2 March 2015

Re: Exhibition of State Significant Development Application for Bringelly Road Business Hub, Leppington (SSD 6324)

I write in response to your letter received by Council on 16 January 2015 in relation to the exhibition of State Significant Development Application for Bringelly Road Business Hub, Leppington (SSD_13_6324).

Appendix A - Site development and lot layout plan

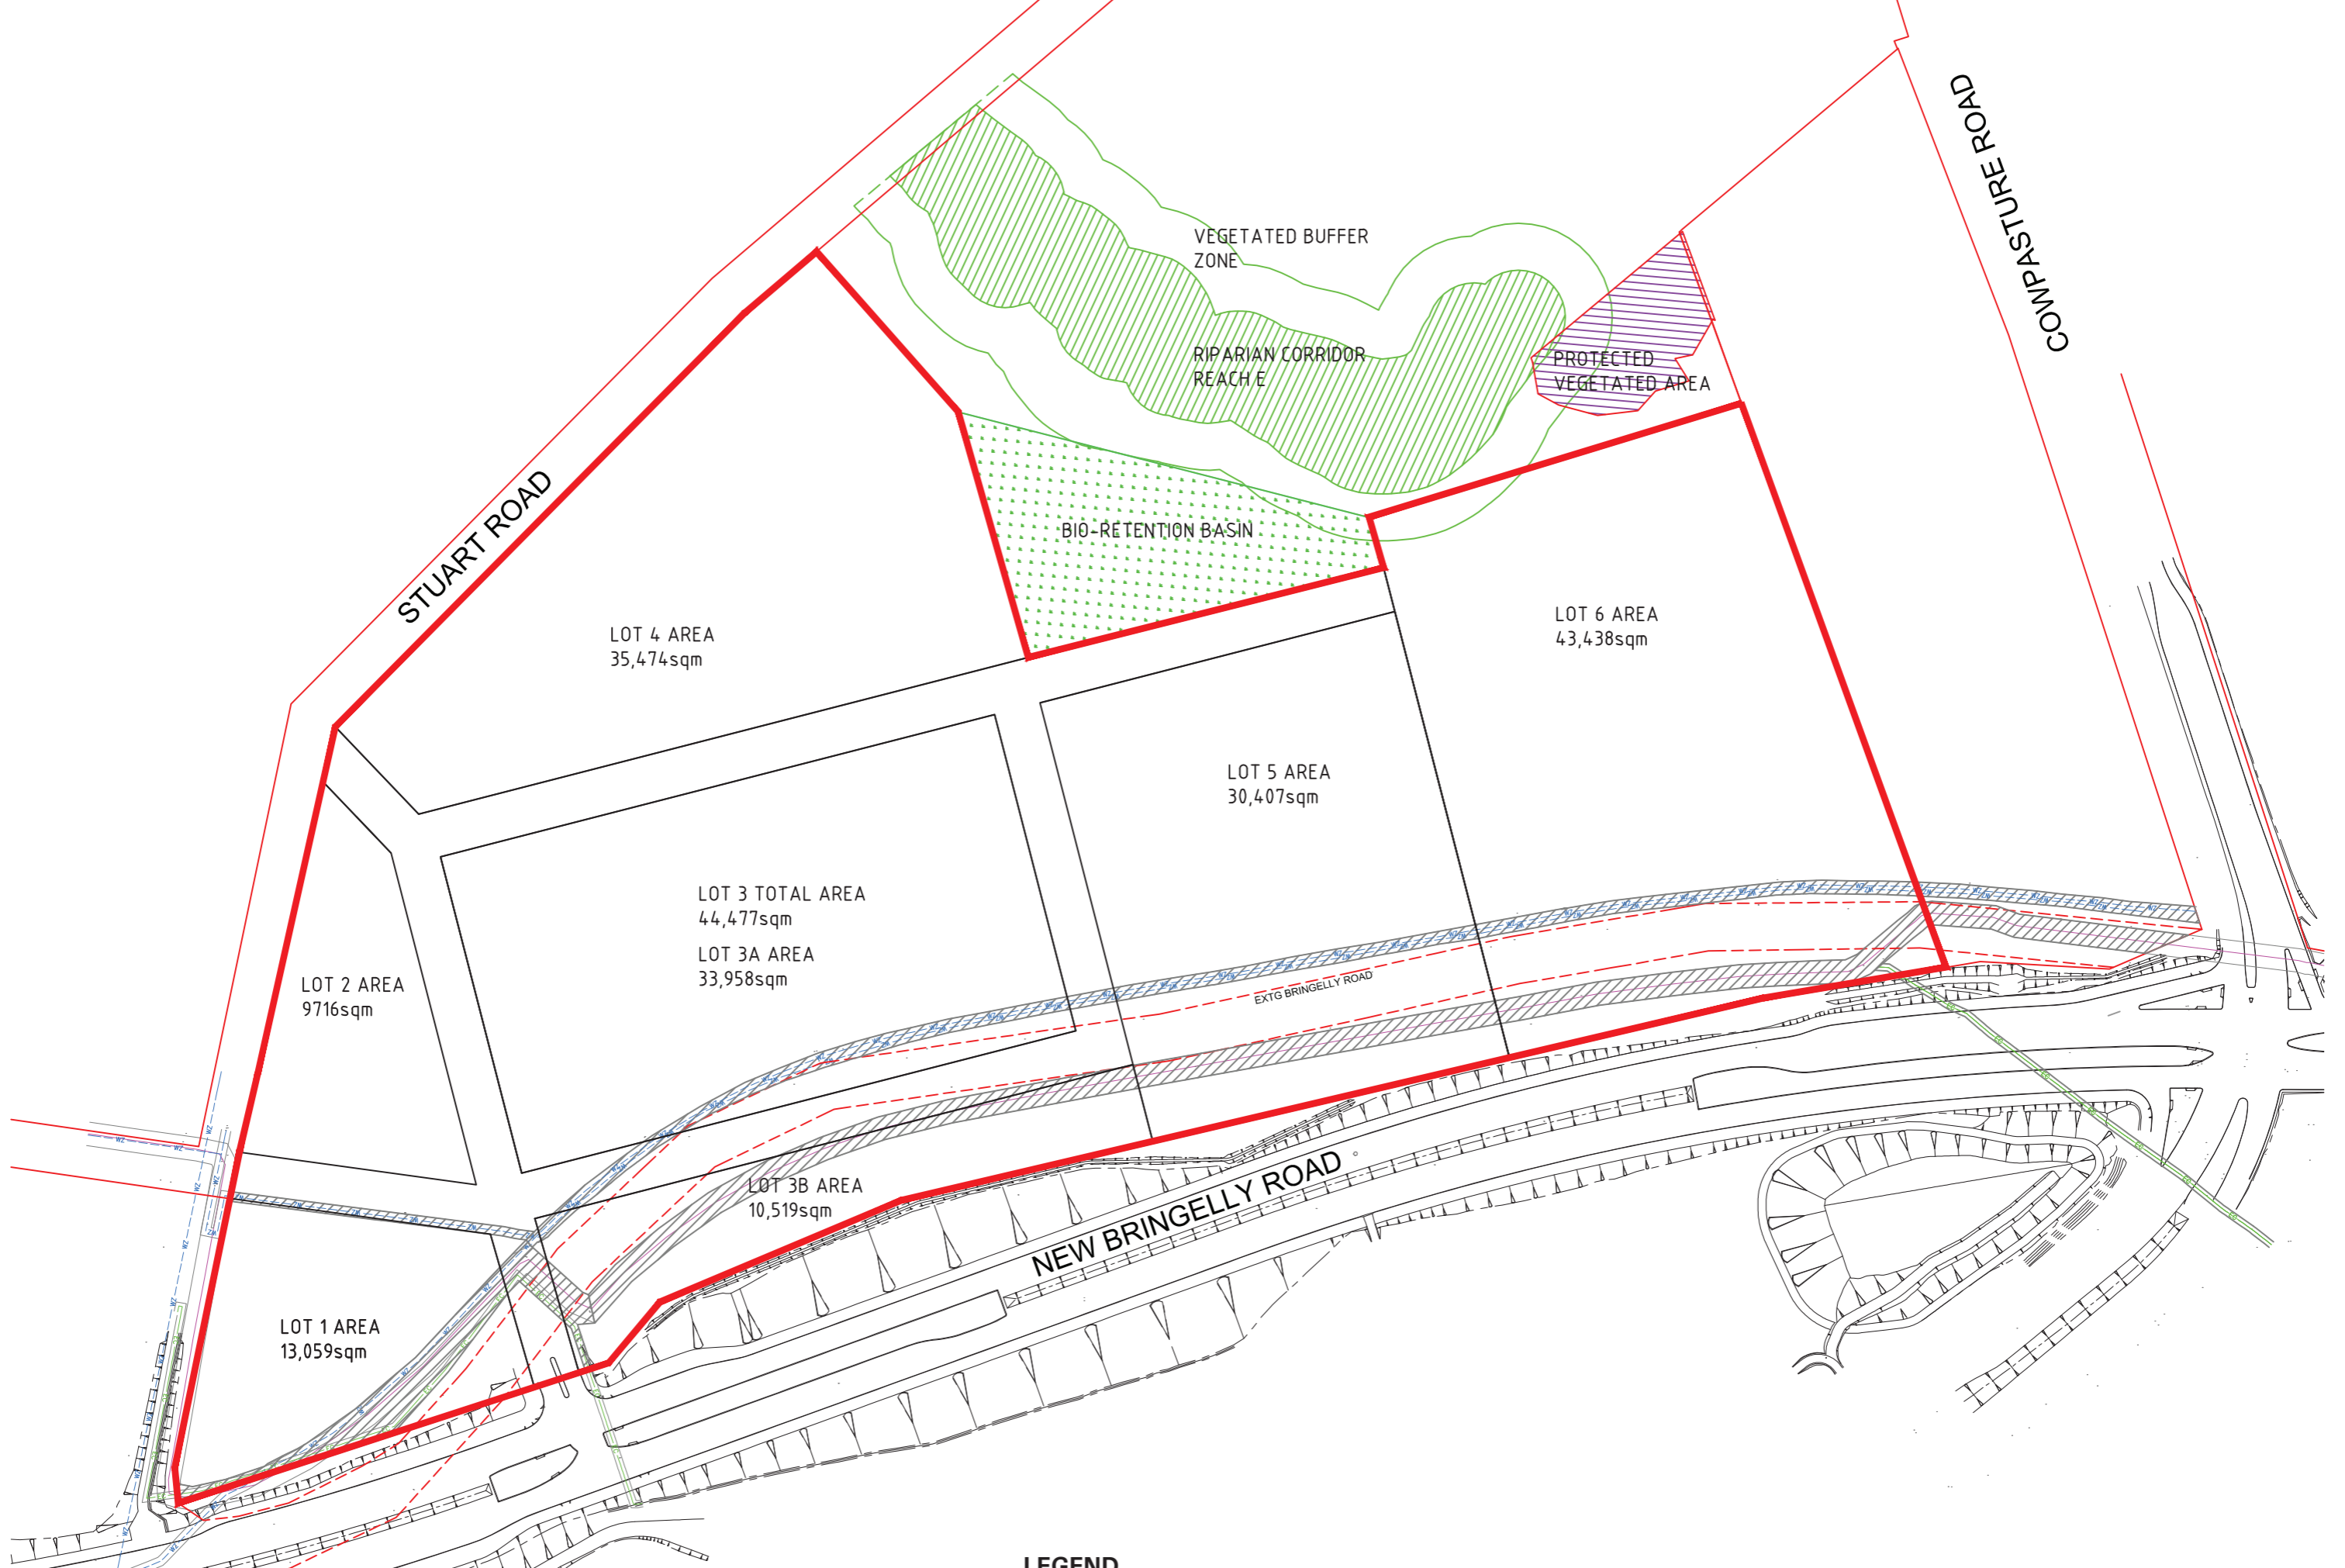
As part of addressing the requirements of the DGRs, the applicant has submitted Site Design Guidelines for the Bringelly Business Hub as Appendix G to SSD_13_6324. Council is concerned that the proposed earthworks and construction of retaining walls fails to meet the urban design requirements laid out in the Guidelines, specifically as they relate to fences, as follows:

- *To provide an appropriate level of security for property owners and contribute to the amenity of the precinct;*
Without details on building materials or finish of the retaining walls, it is difficult to assess how the proposed retaining walls will contribute, or be of detriment to the amenity of the precinct. The height of the proposed retaining walls, being up to 5.4m at the boundary of the service road and Lots 4 & 6 (as shown on drawing DA4.01 revision 8), will significantly reduce opportunities for passive surveillance regardless of any boundary walls constructed.

- *To encourage pedestrian access from the street;*
It is observed that the proposed retaining walls surround most proposed lots, with the exception of 'lot access points', which are assumed to be vehicular access points. Given that these walls will surround each lot (including access between lots) the proposed retaining walls fail to encourage pedestrian access from the street, as movements are restricted to the vehicular access points. The sharp changes in levels between lots are also likely to discourage pedestrian movements between lots.

- *To ensure fencing and walls respond to the topography, streetscape and landscape;*
It is clear that the extent, including the height and number of retaining walls proposed, would indicate that the form of development proposed does not adequately respond to the topography or landscape of the site. Heights up to 5.4m are well above the human scale and are likely to visually dominate the site. It is clear from the controls that heights of up to 1.2m are desired; the proposed

retaining walls represent a significant modification of this control that has not been addressed in the EIS.

- *To enhance the visual outlook of adjoining rural residential properties.*
Without a schedule of finishes, details of building materials, combined with the number and height of retaining walls proposed, it is impossible to assess whether the proposal meets this objective. Retaining walls represent an urban design outcome similar to that of blank walls of commercial/retail premises or residential towers. Such blank walls are discouraged as they do not allow active engagement with the streetscape, are prone to vandalism, detract from visual amenity and do not meet the requirements of crime prevention through environmental design (CPTED) principles. The significant stepping of the land, in combination with the height and extent of retaining walls is likely to significantly reduce the visual outlook of adjoining residential properties.

It is recommended that the applicant be requested to redesign the site layout such that any proposed changes in levels more appropriately meet the Site Design Guidelines.
